Application for a Non-Material Amendment Following a Grant of Planning Permission

Erection of two storey side extension and single storey rear extension. Internal alterations. Alterations to roof. Alterations to fenestration. Rooflights. PV Panels. Sun tunnel. Juliet balcony.

23/01483/HOUSE

Alterations to fenestration

Plans and Elevations as proposed, Block Plan scale: 1:50/1:100/1:500 @A1 drawing no.

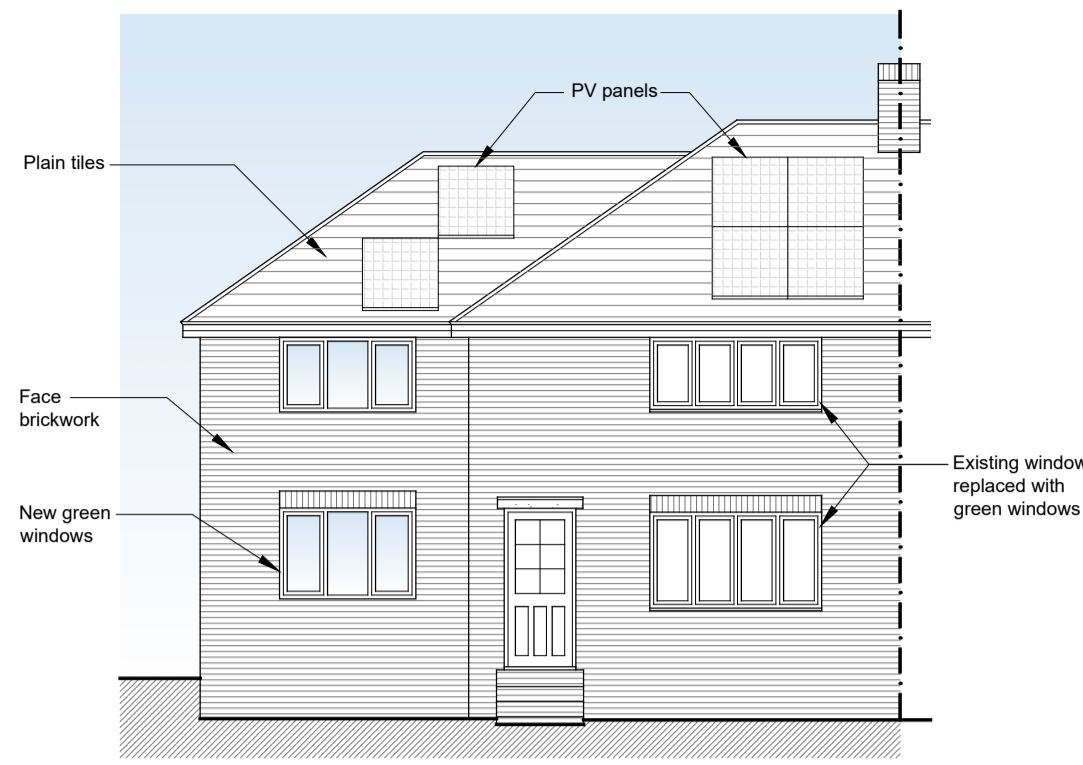
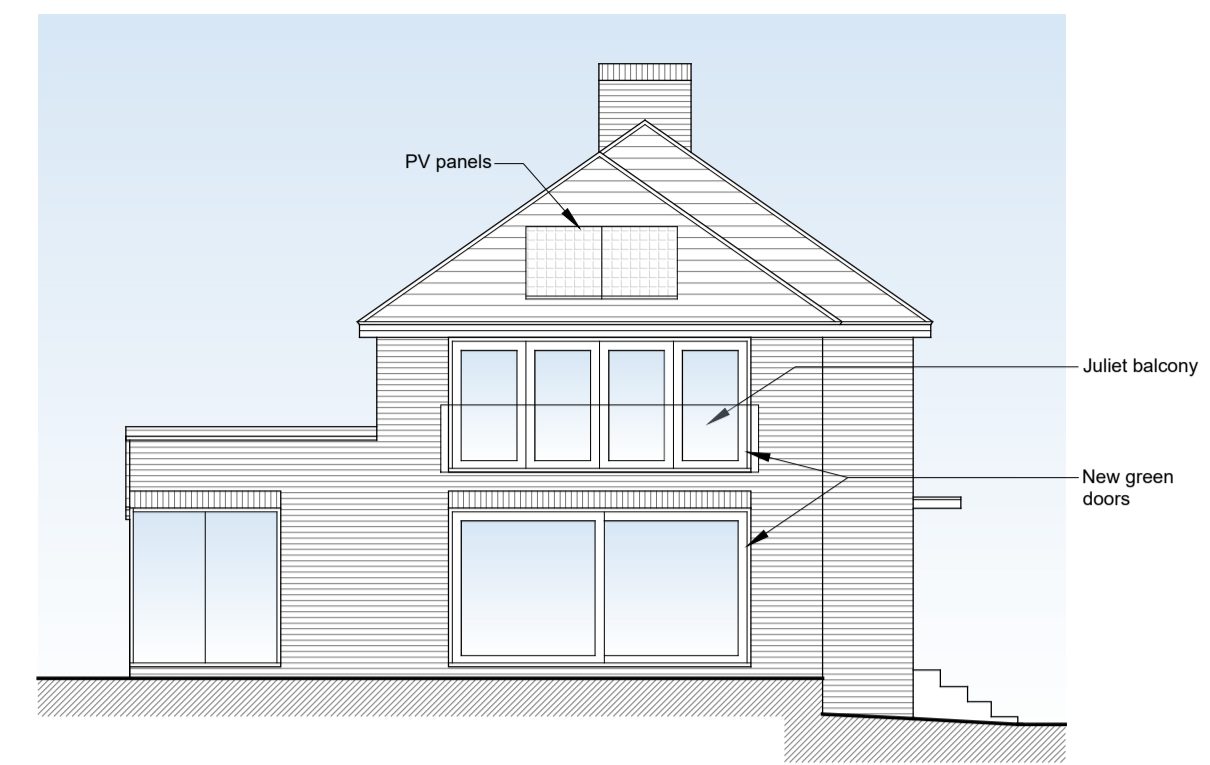
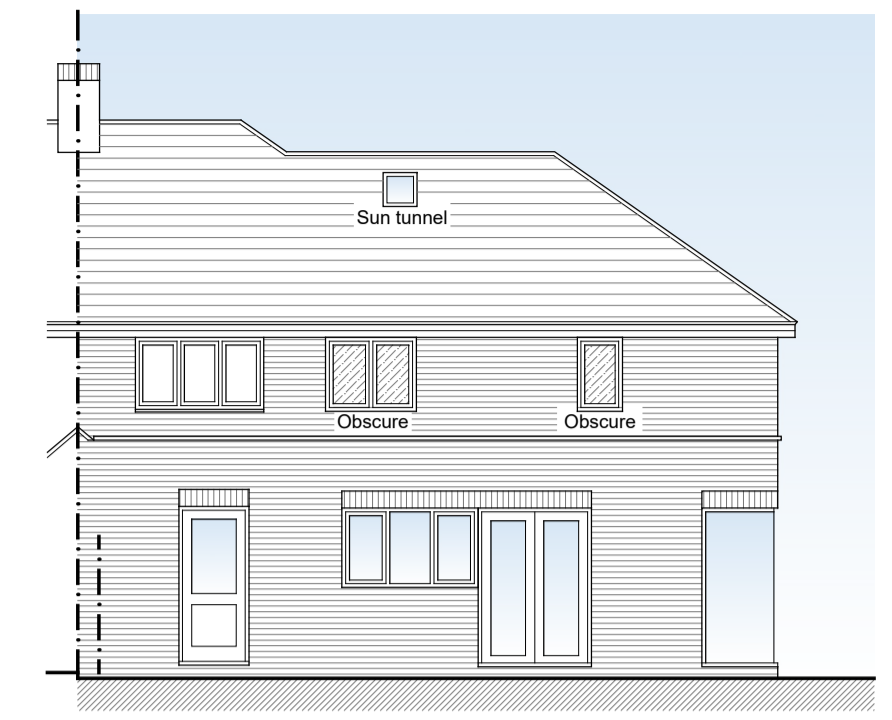
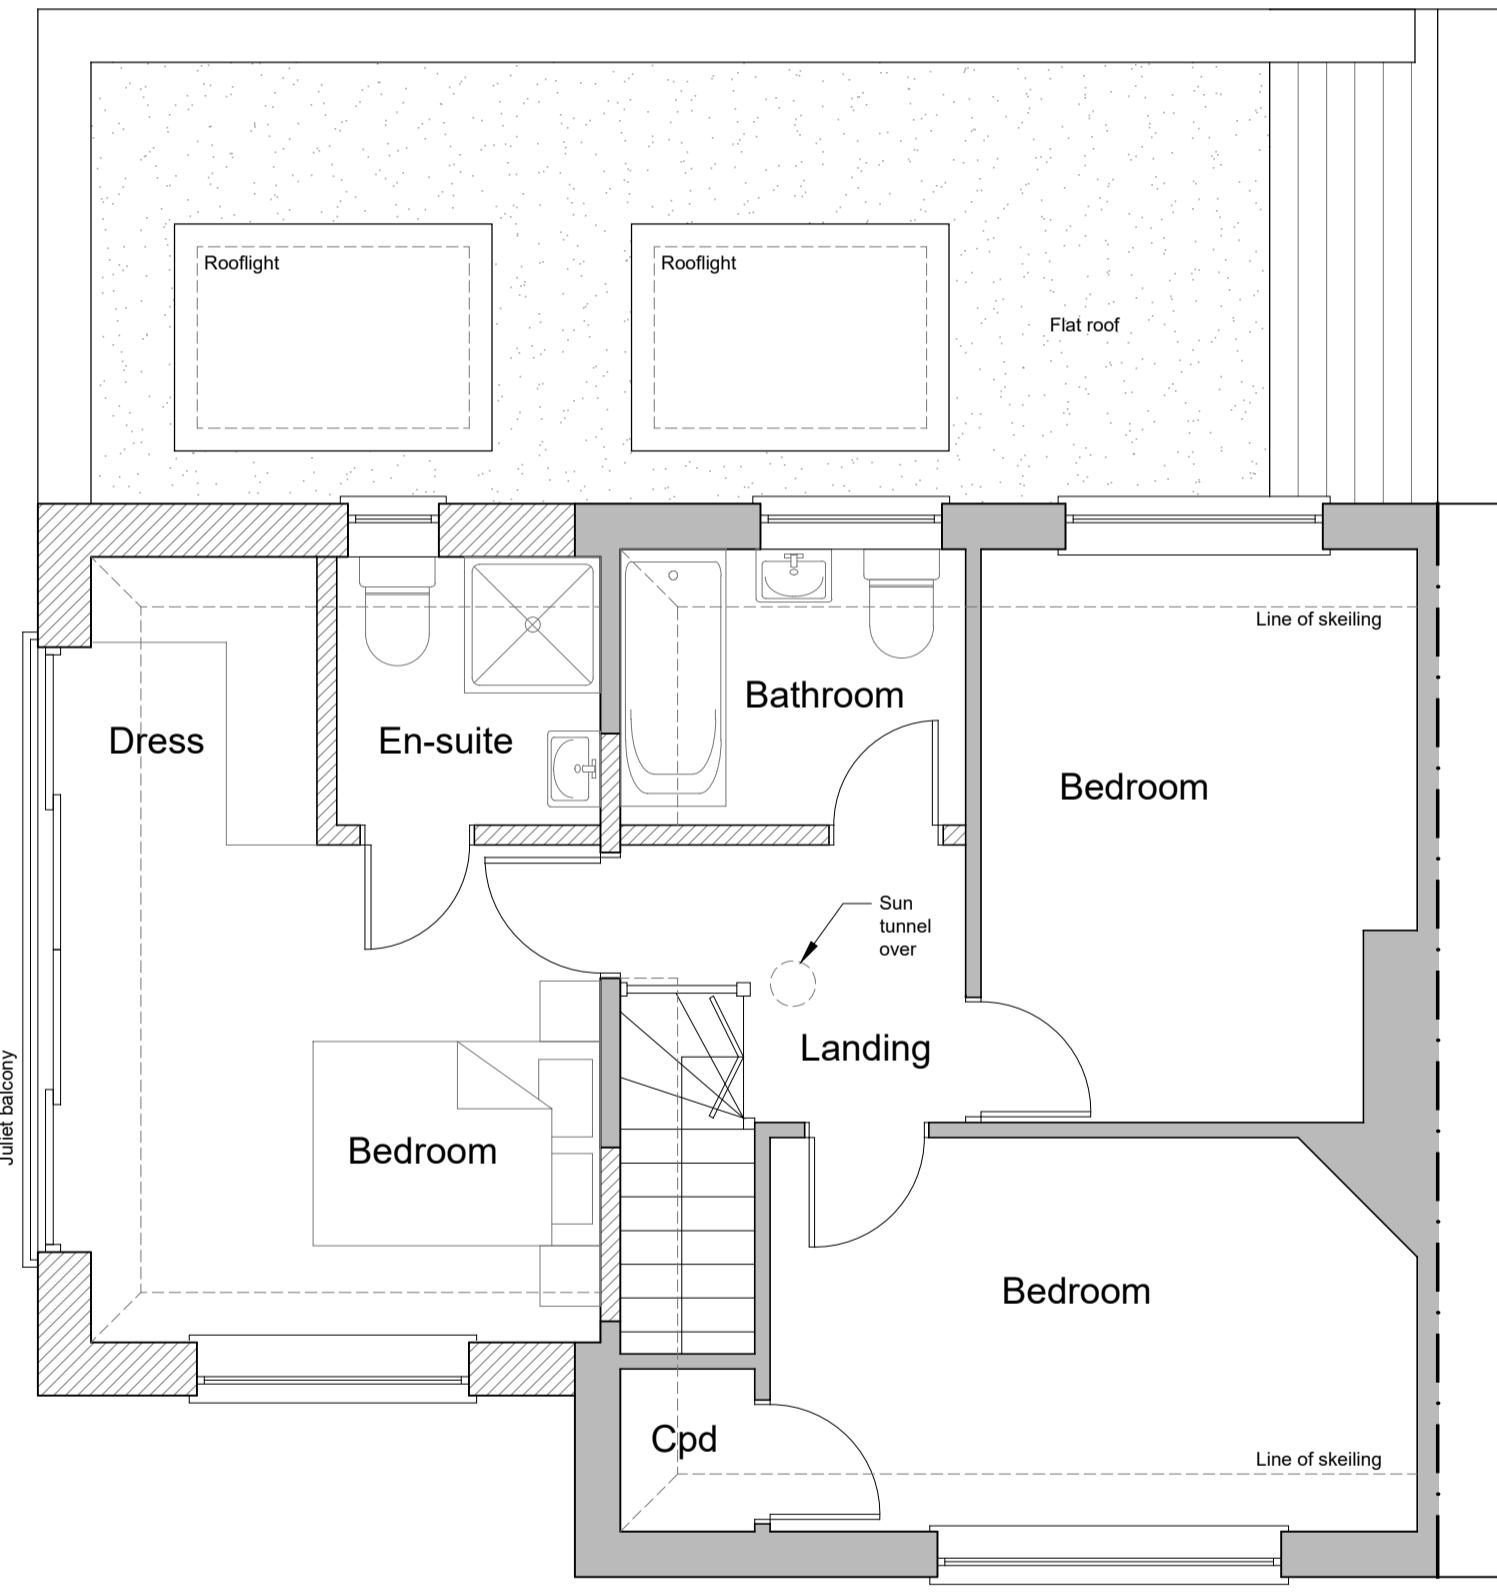
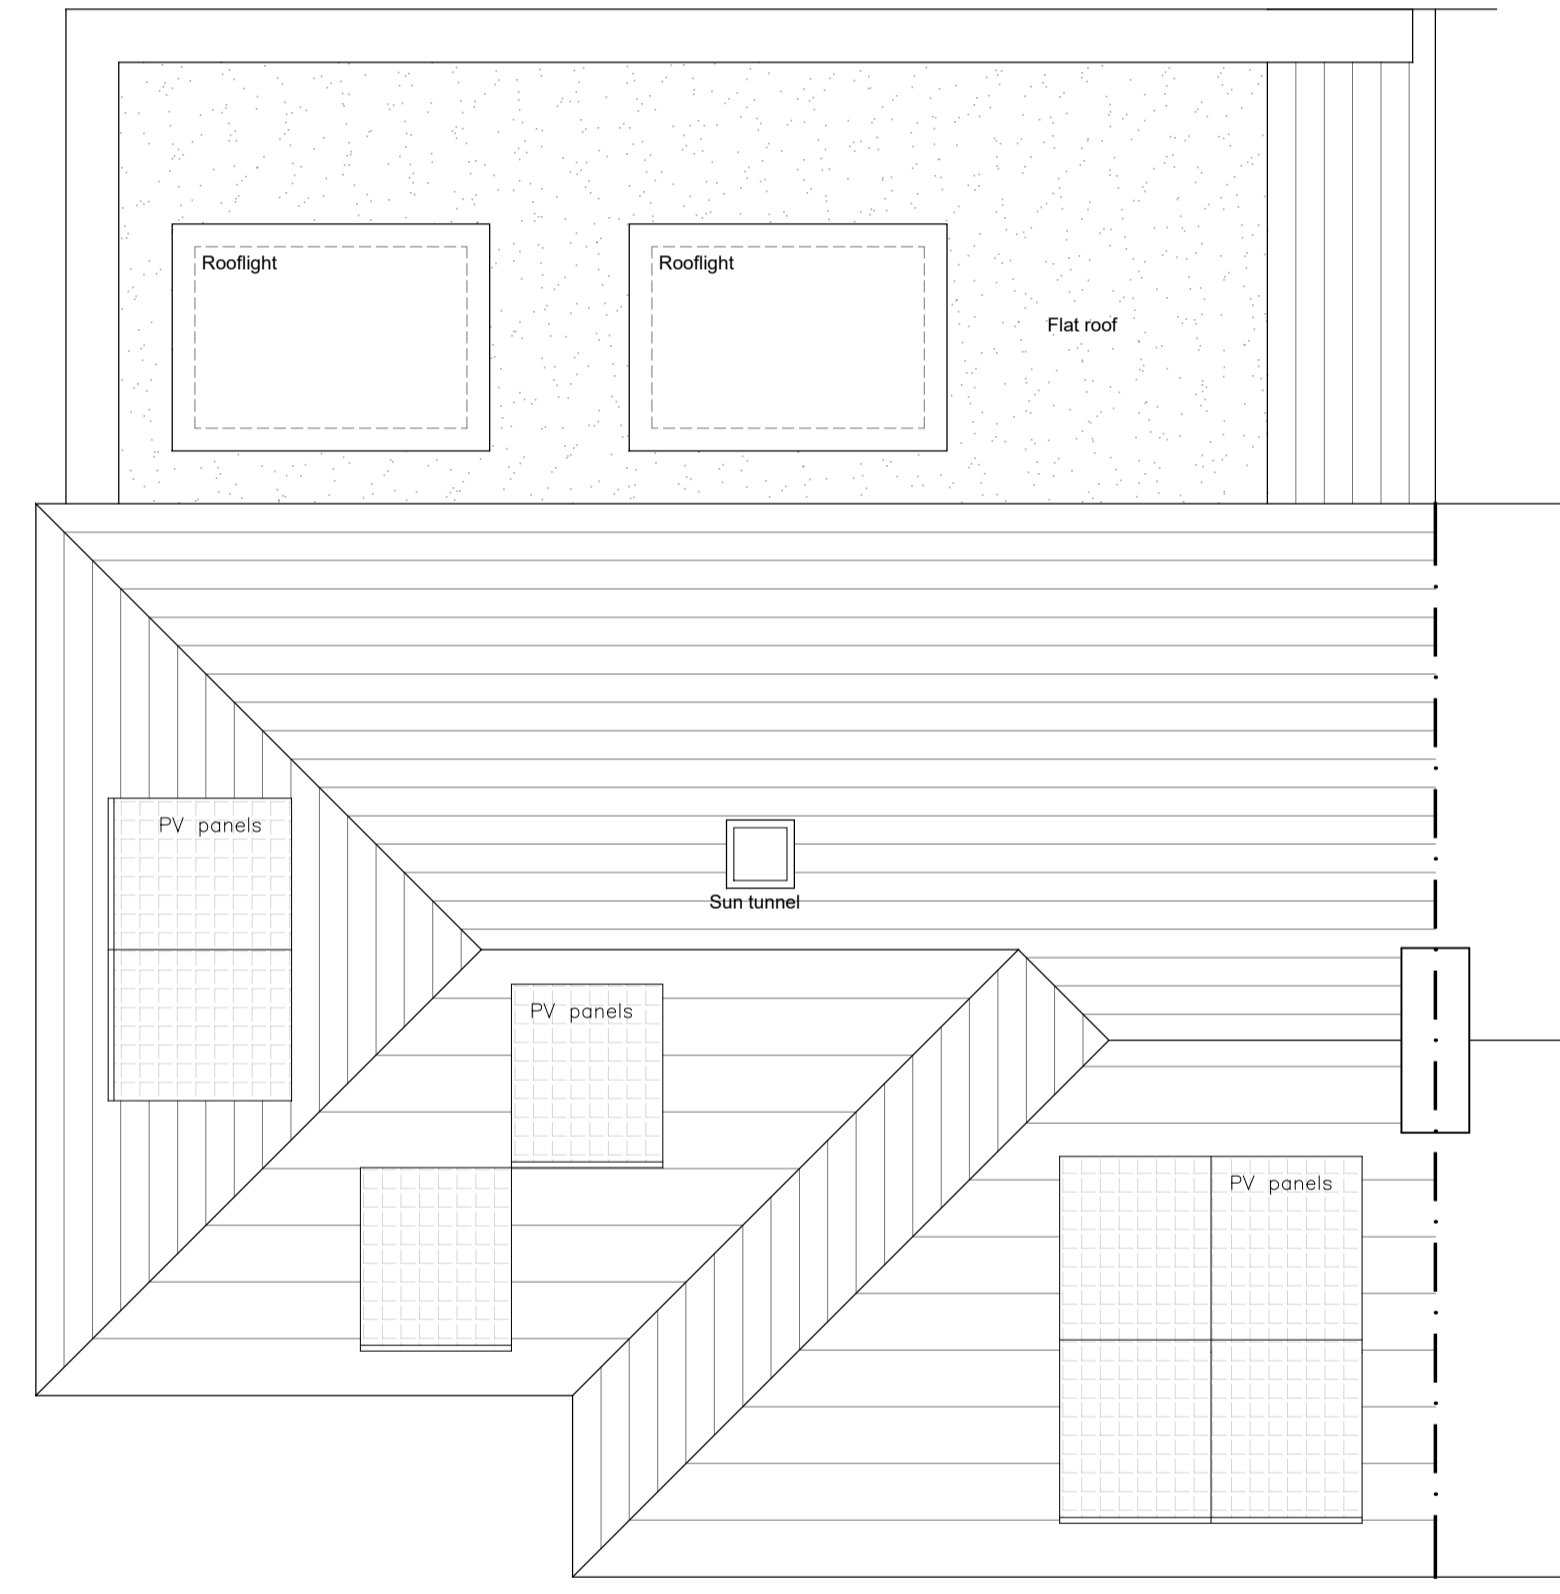
The applicants wish to make the most of the views to the side of the property and increase the size of the sliding doors and juliet balcony, this has in turn amended the first floor layout and removed the previous dressing room window to the rear. There are no neighbours to this side of the property and will therefore not have any impact on privacy.
